Whether the proposed extension to rear of existing vernacular stone cottage at Townleyhall, Drogheda, Co. Louth is or is not development and is or is not exempted development.

Stone cottage at Townleyhall, Drogheda, Co. Louth

S5 2019/53

Inspector

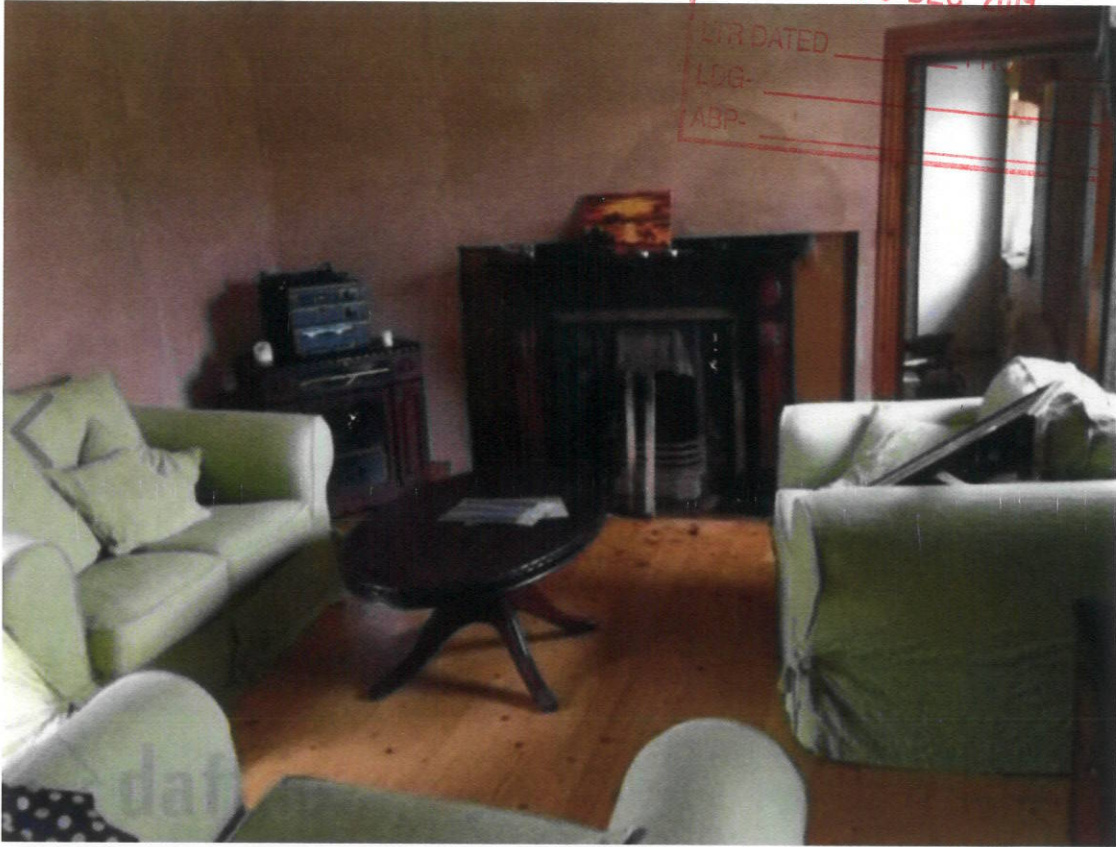
- They provide that the existing plans submitted are inaccurate in that they have not demonstrated the former derelict condition of the said structure.

- The property is located within Townley Hall Conservation Area.
- The drawings submitted are not accurate drawings of the structure on site at present or before the commencement of the current works. They are misleading and they refer for example to a disparity in the height of the eaves.

materially affect the external appearance of the structure. However, having regard to the details submitted I would consider that the works to the former structure are significant and would materially affect the exterior of the structure so as to render the appearance inconsistent with the character of the structure or neighbouring structures. Therefore, I would not consider that this exemption would apply.

- 8.4.2. Of issue also is compliance with Class 1, Schedule 2, Part 1 of the Planning and Development Regulations, 2001 (as amended). As the Referrer considers this to be an extension to an existing house, they contend that the proposal for an extension under 40sq.m would fall within the conditions and limitations set out under the said Class. They provide a discussion of the extension relative to the conditions and limitations in this Class and consider that it complies with these exemptions. However, it is of note that the Description of Development for Class 1 refers to *Development within the curtilage of a house*. The issue of lack of clarity as to whether this structure could have been considered as a 'house' or a 'habitable house' has been noted above. Therefore, I would not consider that it has been established that this exemption would apply relevant to the subject Referral case.
